**APPLICATION NO. LU/114/15/RES – RESPONSE TO WEST SUSSEX COUNTY COUNCIL (WSCC)
Construction of access road to north of Toddington Lane, east of proposed Southern Lymminster
Bypass and west of Parcels B3 and B5
Land North of Toddington Lane, Littlehampton, West Sussex, BN17 7PP**

I refer to the above application and to the comments received from WSCC dated 16 September 2015. I confirm that the project team has reviewed WSCC's comments and I set out our responses below:

Drawing No. CV/8140927/600-1 Rev P7

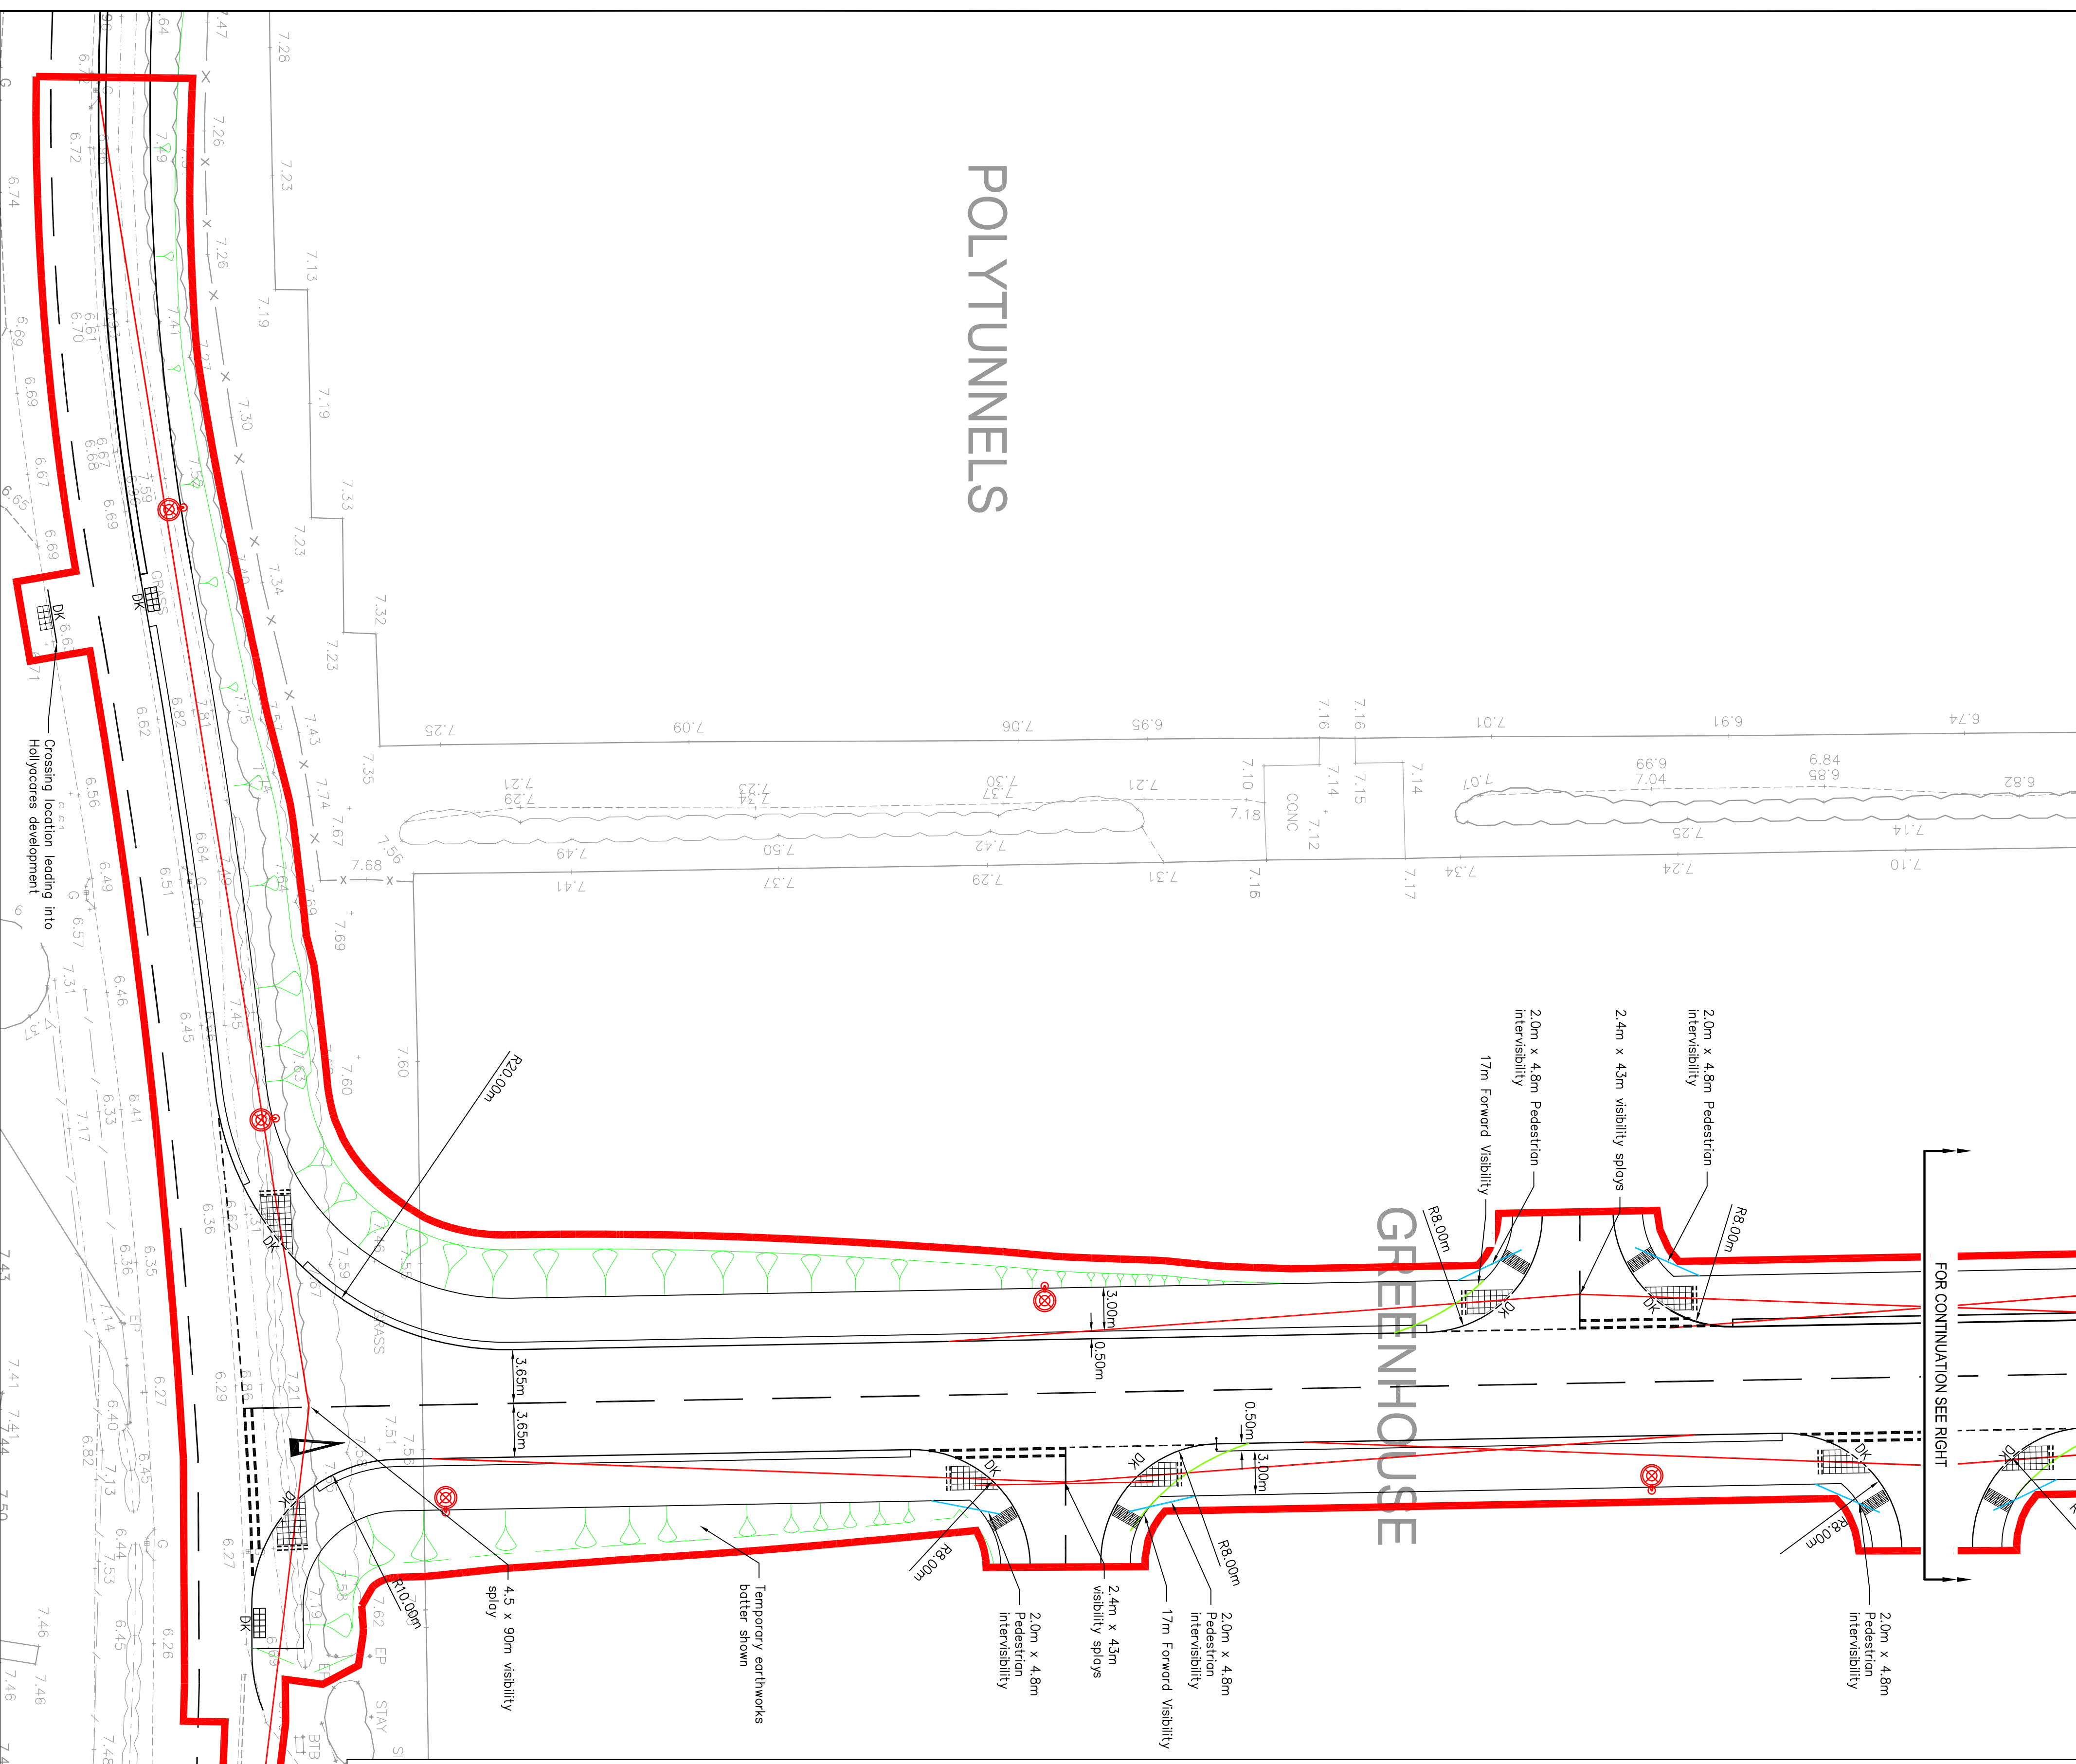
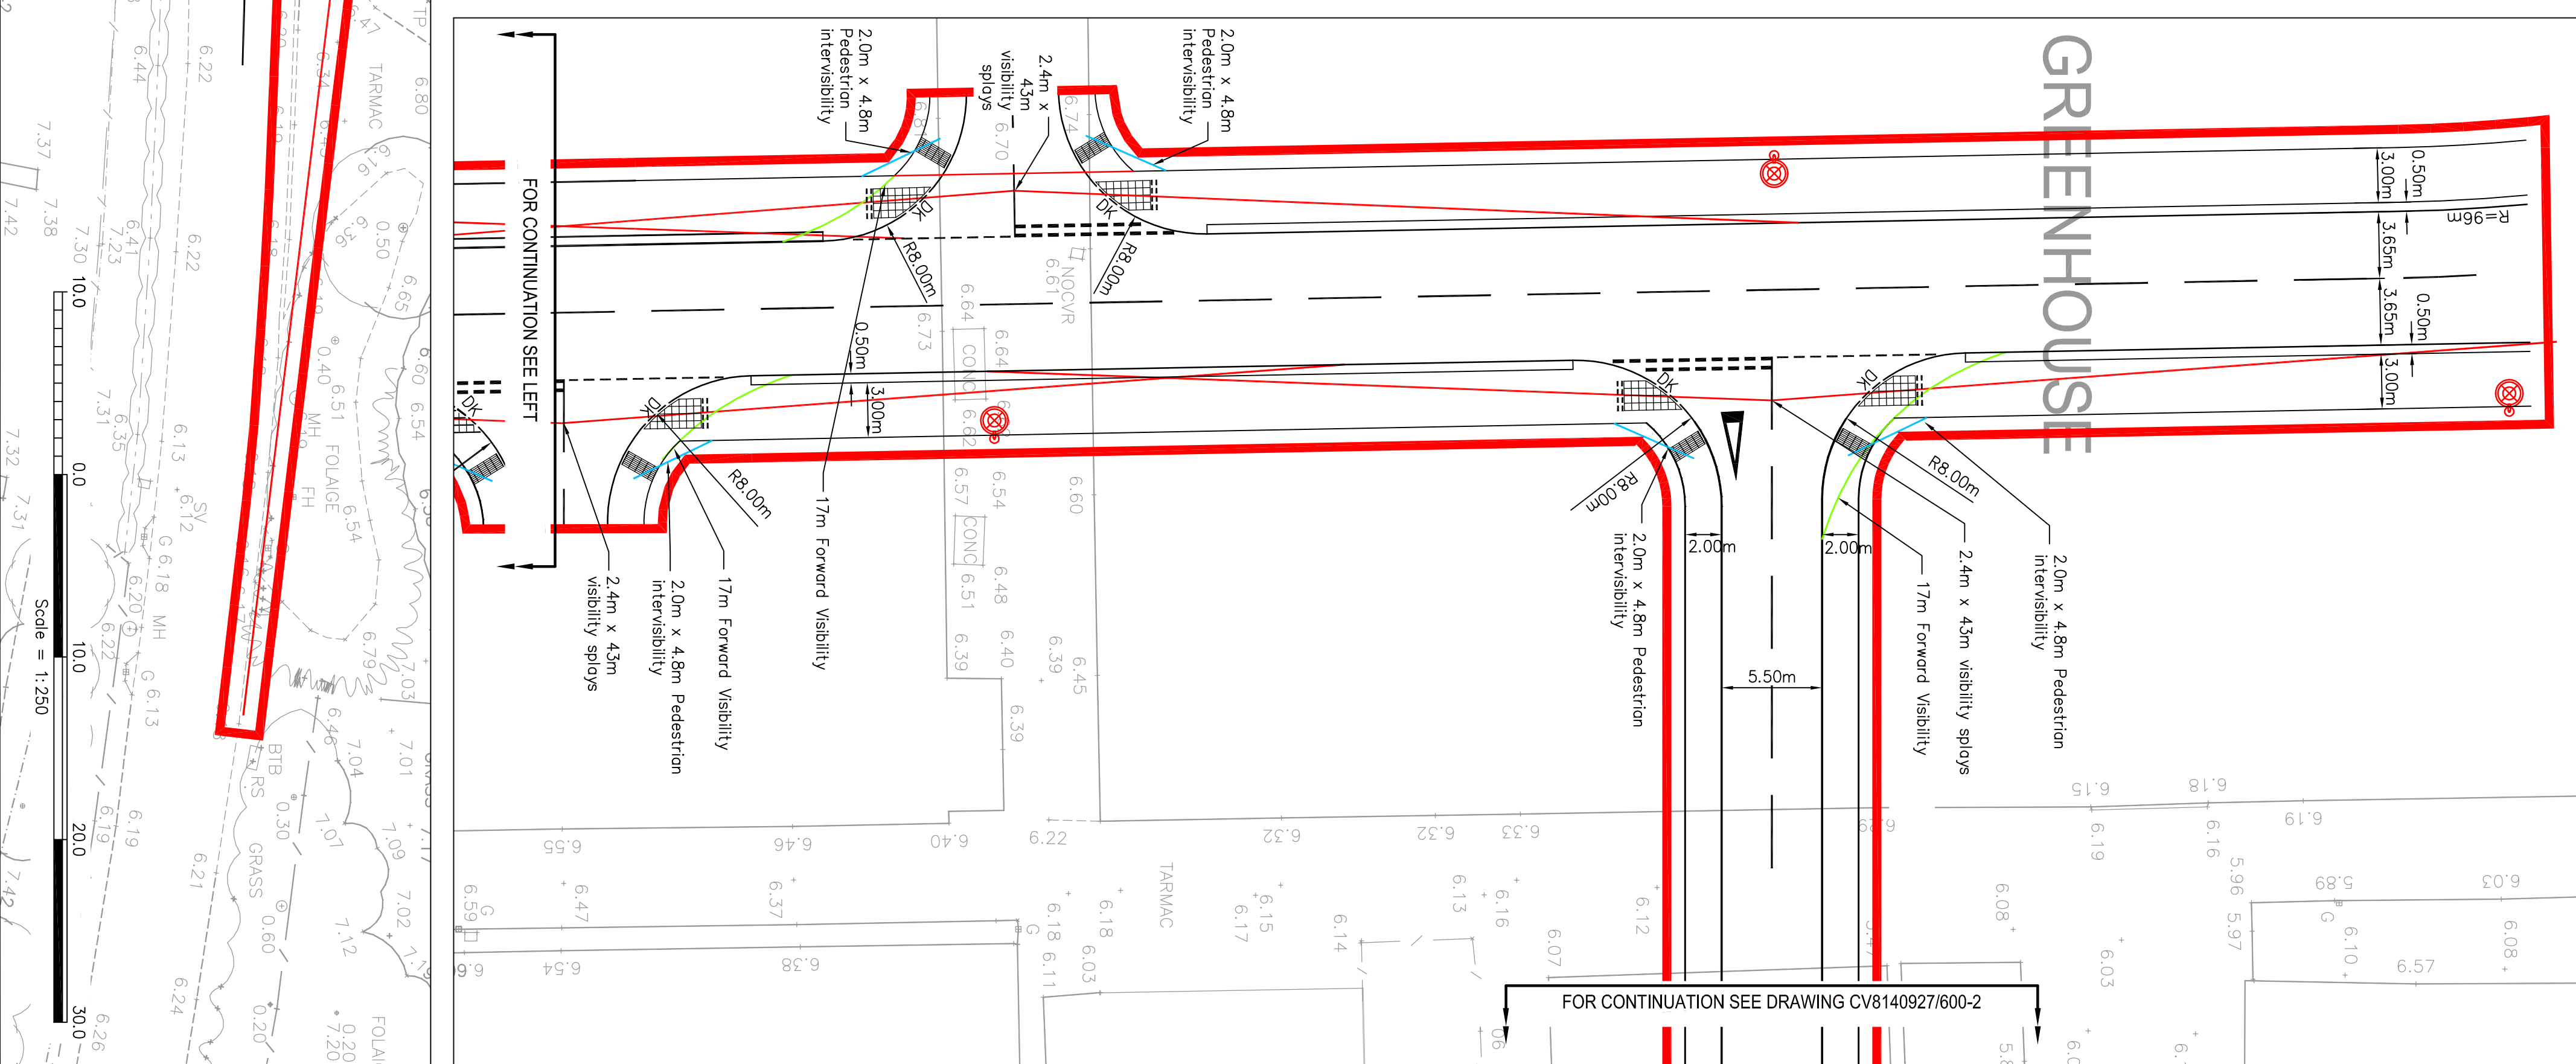
3. Visibility Splays

4. Cycle / Pedestrian Intervisibility

The visibility splay is shown as requested on amended drawing CV8140927/600-1 Revision P7 enclosed with this submission.

The guidance suggested recommends a minimum speed of 6mph can be adopted for the cycleway which is considered appropriate on the basis that cyclists would be slowing down significantly on approach to the tactile crossing point. A speed of 6mph equates to a SSD of 4.8m based on the SSD equation provided in Manual for Streets. The WSCC recommended cycle guidance allows a minimum 'x' distance of 2.0m which would be suitable for pedestrians and the resultant splay of 2.0m x 4.8m have been measured from the centre of the footway, in accordance with the methodology provided in the guidance, and have been shown on the revised drawing CV8140927/600-1 Revision P7 enclosed with this submission.
